Park and Recreation Department

MEMORANDUM

RE: Rezoning Petition #2022-084
PID# 02961112

**SCHEMATIC**  
**SITE PLAN**

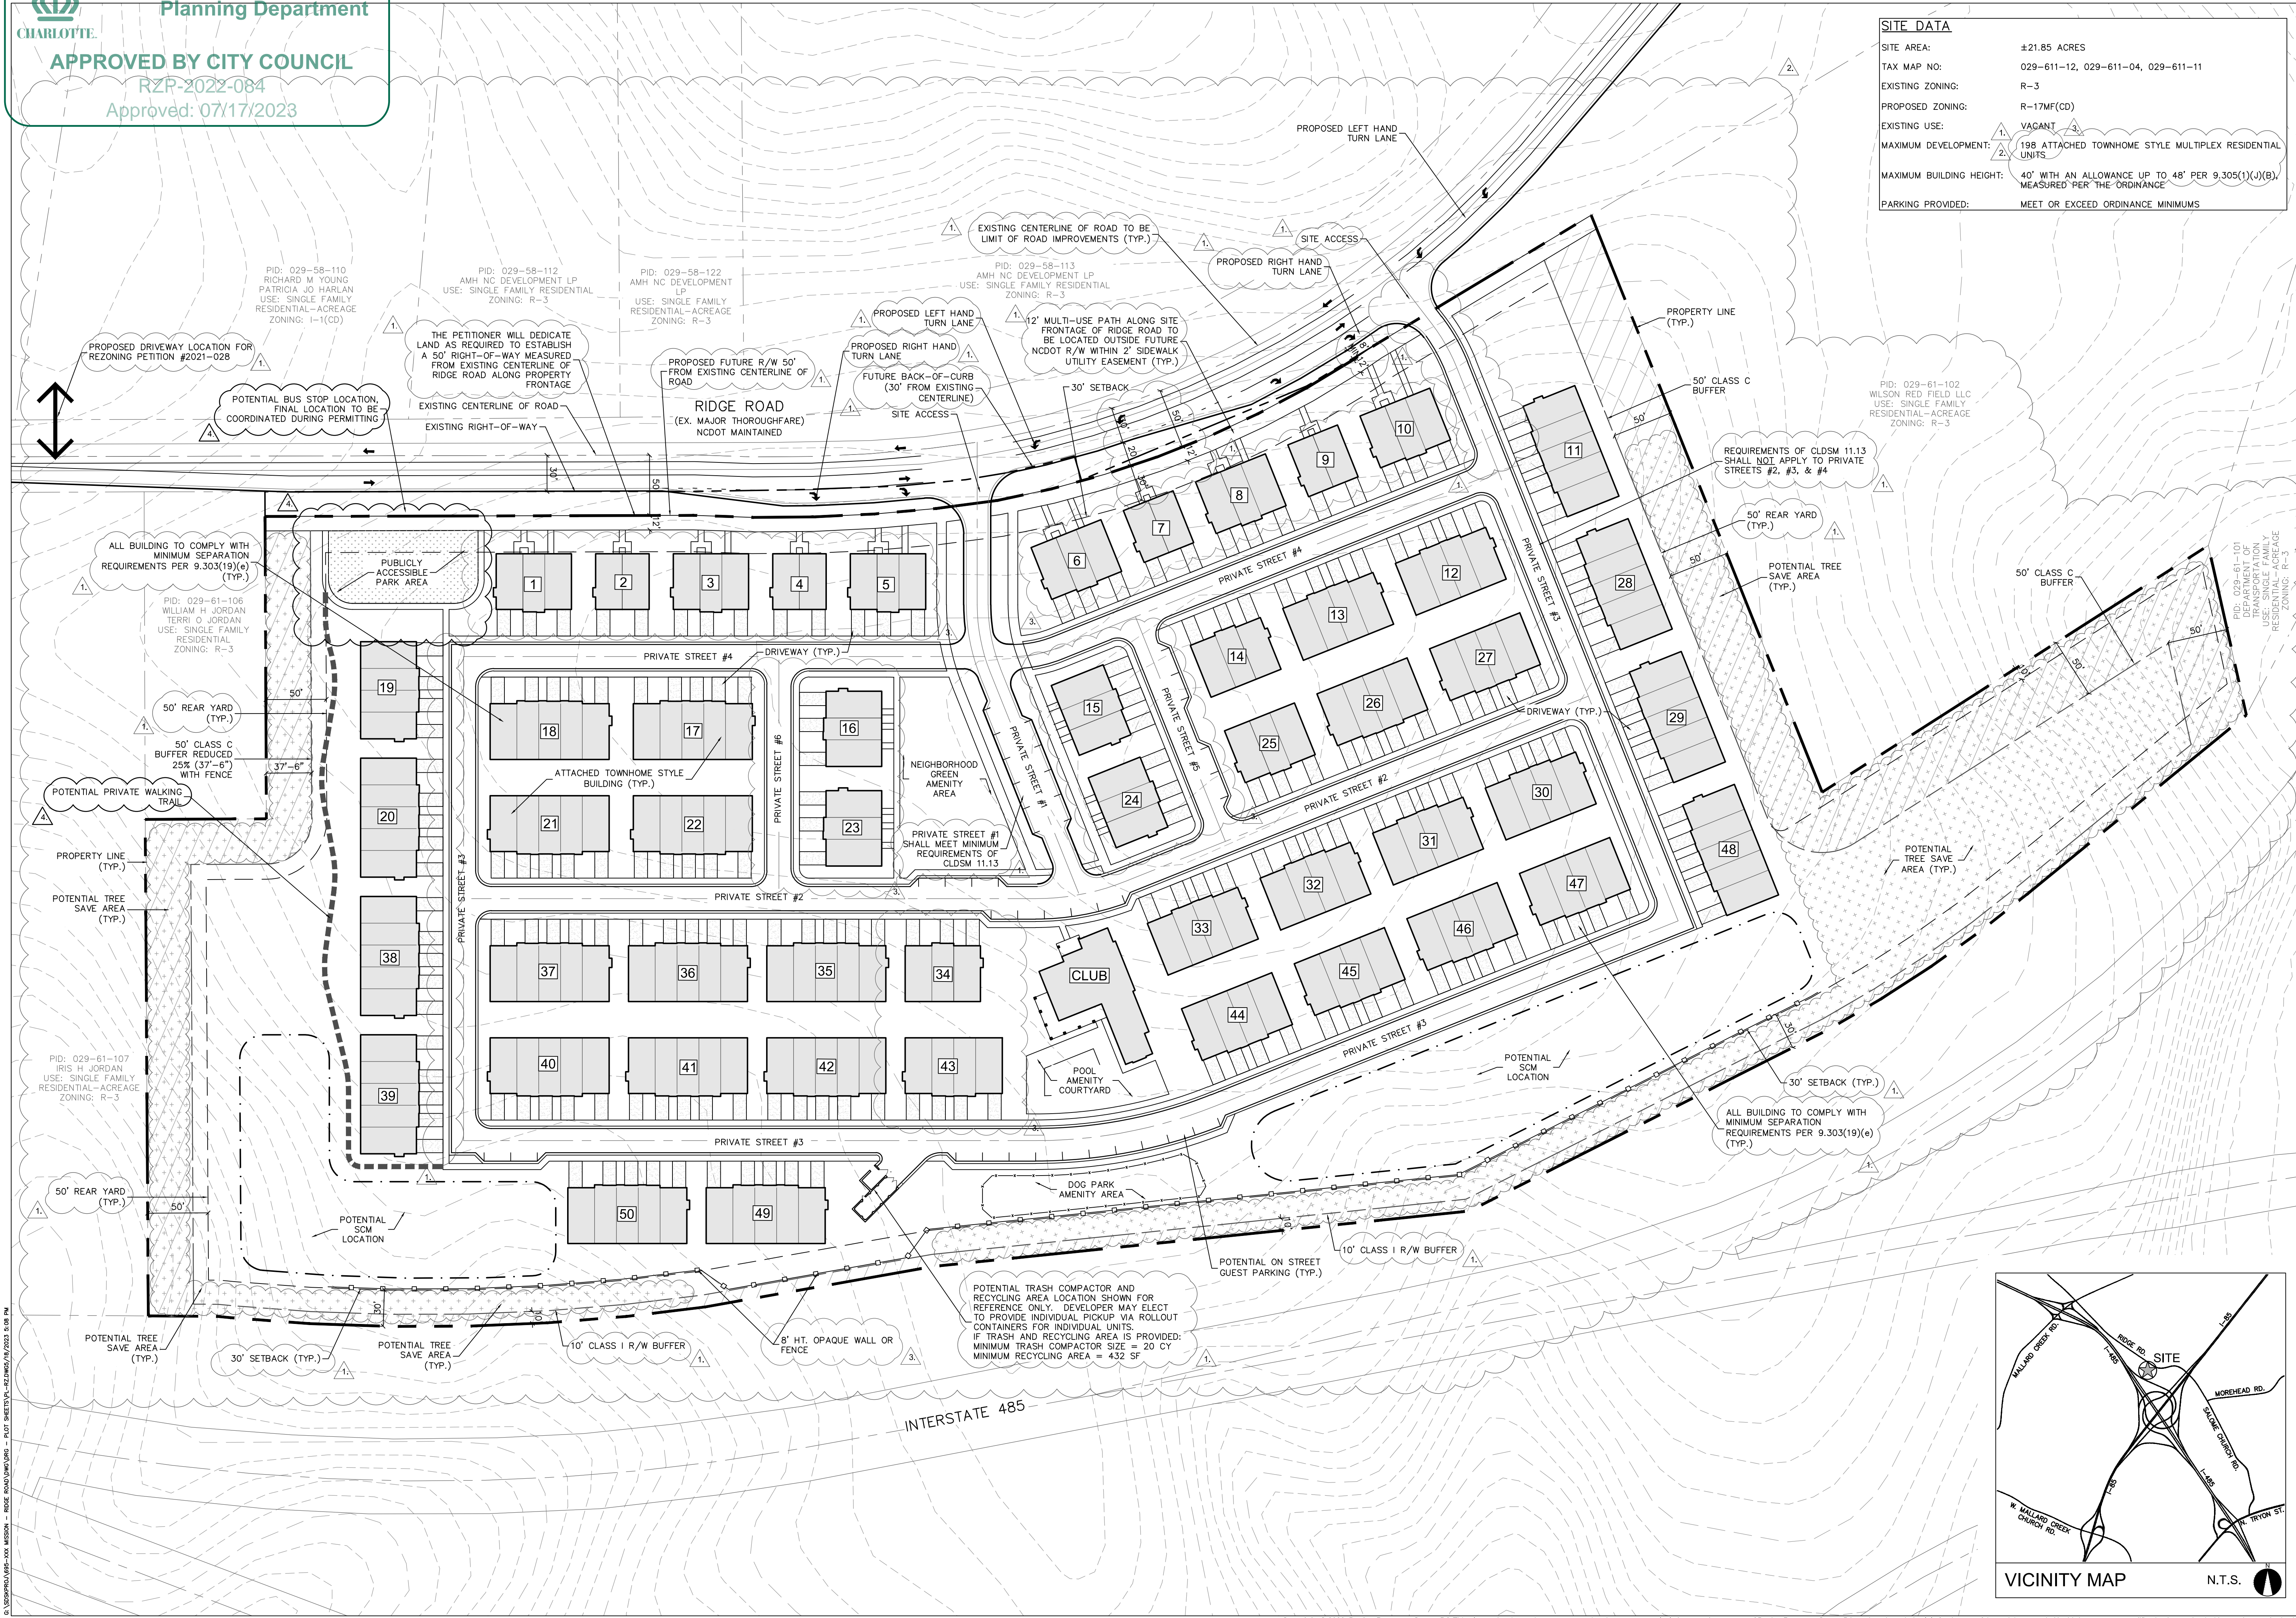
MCPR requests a minimum of **1.0** acre to be dedicated and conveyed to Mecklenburg County for a future neighborhood park. This requested park land shall be adjacent to a public right-of-way for access and is conducive for the development of the typical amenities found in a neighborhood park and cannot include tree save parcels or stormwater BMP's.
